From: Juan Baeza
Sent: 28 June 2018 08:47
To: Planning.Responses
Subject: WA/33/18/OUT

From: [REDACTED]
Sent: 27 June 2018 13:07
To: Chelsey Carter
Cc: Juan Baeza
Subject: RE: FW: Spindlewood

I am dealing with a re-consultation of planning application WA/33/18 however I am unable to respond fully as there is still information missing that I require. The applicant has now provided swept path diagrams for a refuse vehicle but I am still unsure of the visibility splays and the actual speed of the road. I asked for a speed survey and visibility splays taken to the nearside kerb. Will these be provided as I have no other comments other than the ones I made previously asking for these things.

Drawing No.
DPA 13

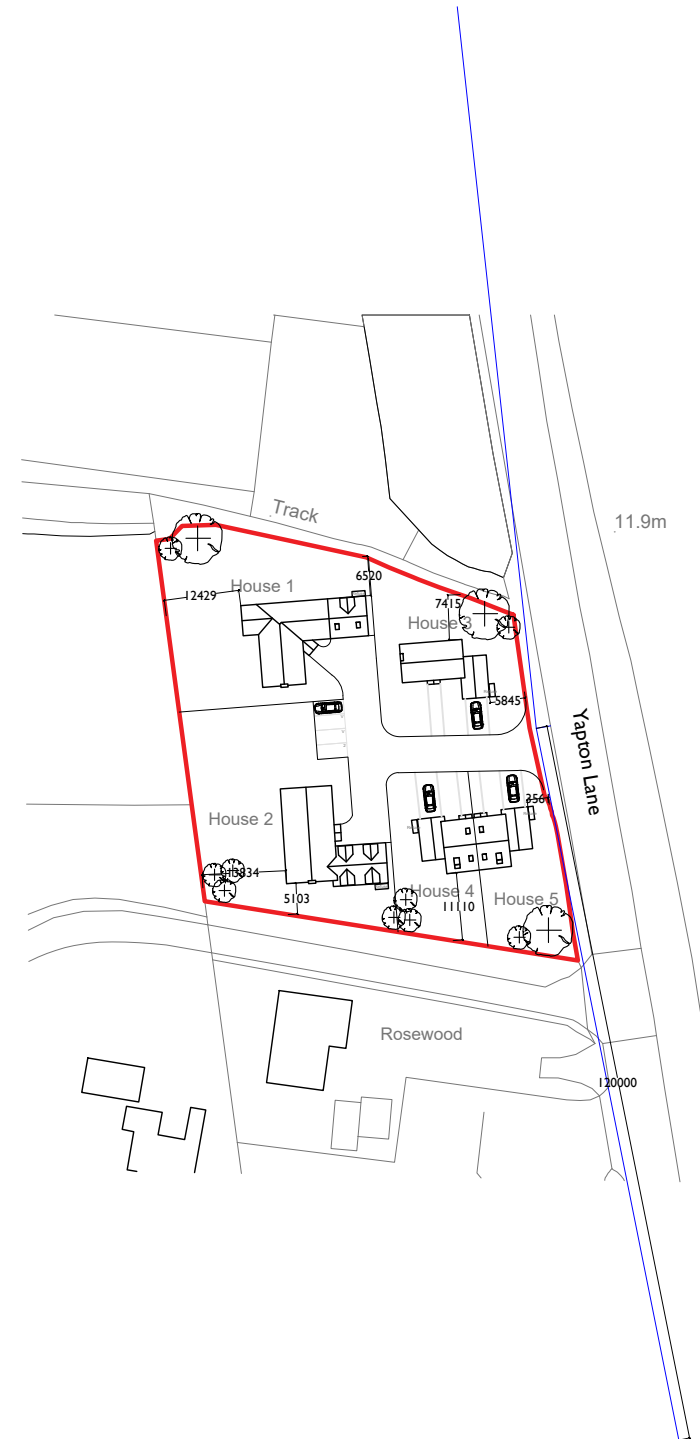
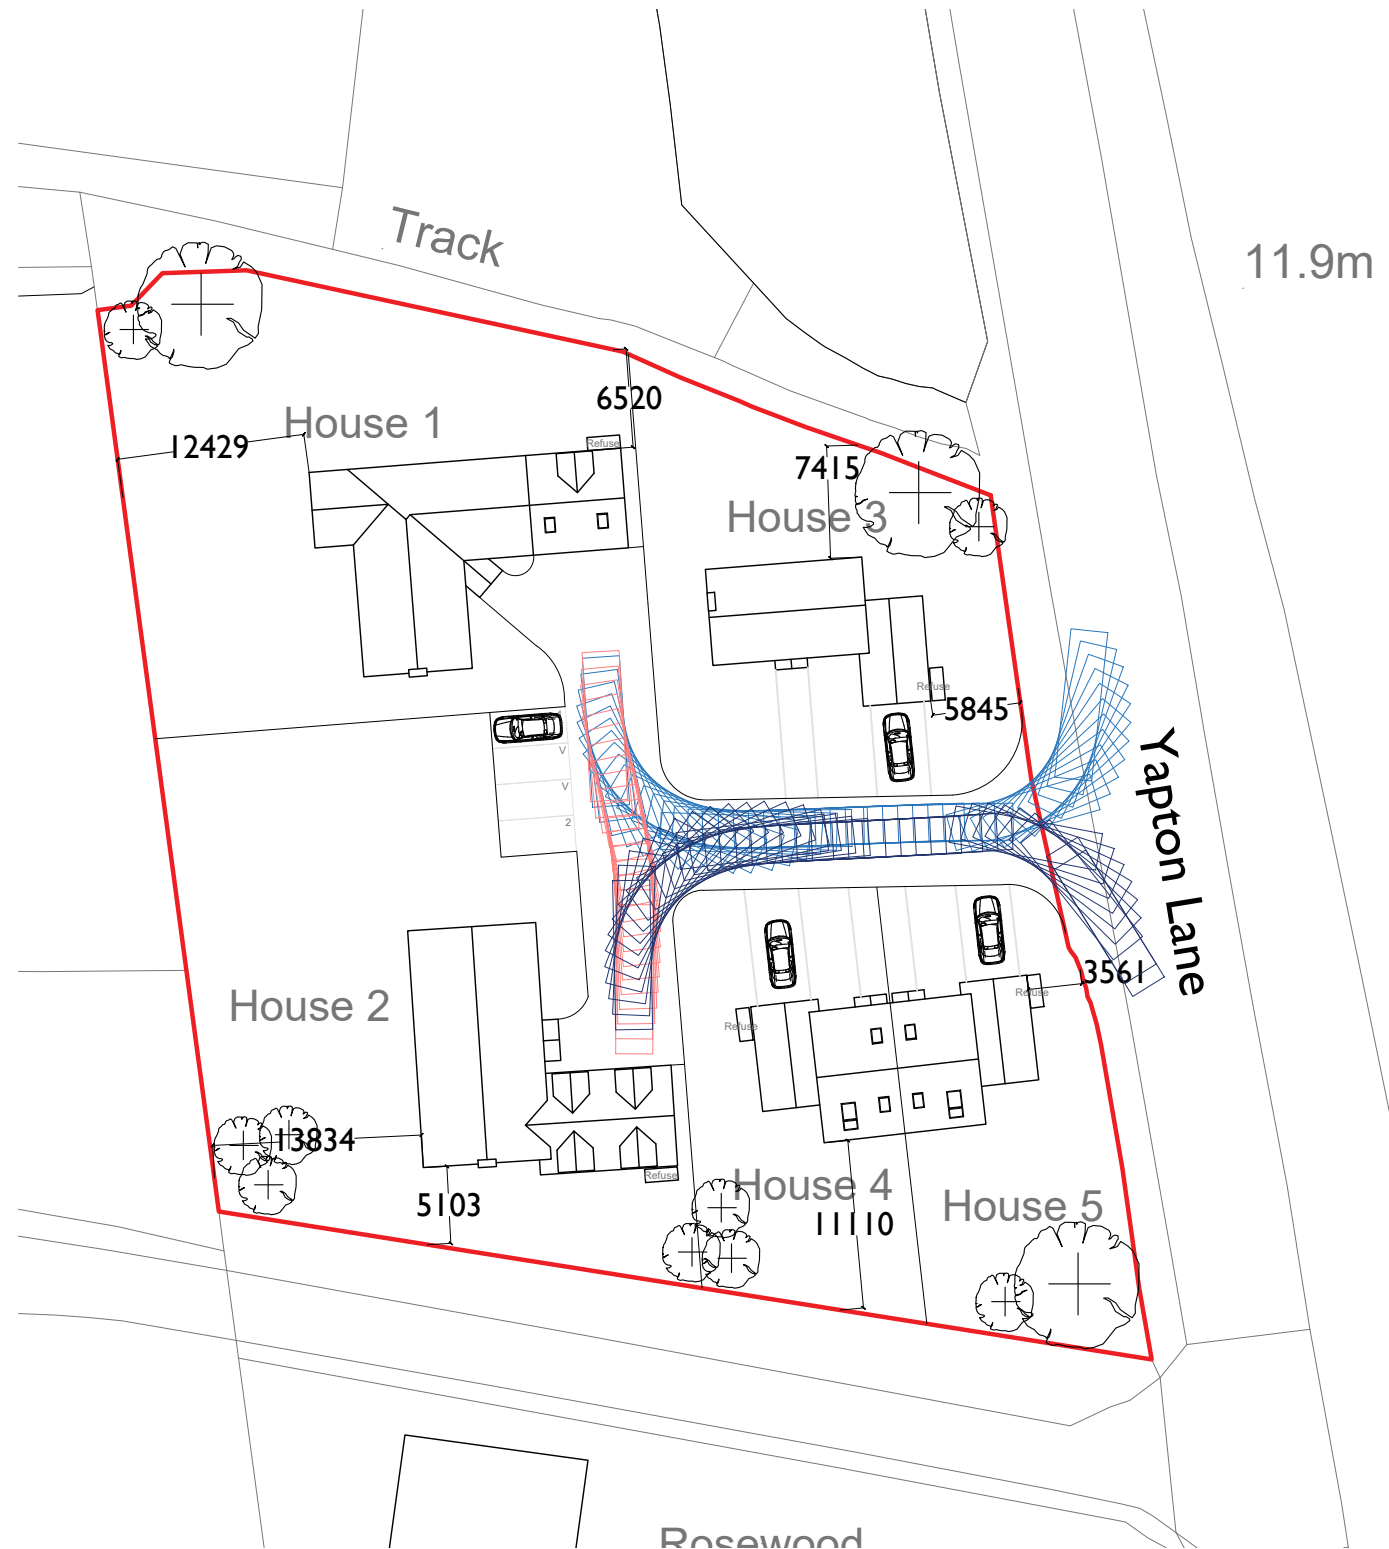
Many thanks for this. Based on this drawing DPA 13 – Visibility splay, we can accept the access in this position with these splays. One other question, are the splays drawn to the nearside kerb or off set by 1m? It seems that the northern splay is to the centre line? This would be acceptable as it is not the leading splay but I do need this confirmed. Do the splays go over third party land at all? It doesn't look like they do but can you confirm this please?

I can see a blue line on the plan but it doesn't have any annotation on it to say its 120m. Furthermore is this set back 2.4m or 2m? This should be shown as otherwise its open to interpretation.

If the 120m visibility can be provided in both directions then this will be acceptable for a 40mph road if set back 2.4m and no speed survey will be required.

Please find attached DPA 13 – Visibility Splay. This is show with dimensions of 2.4m and 120m.
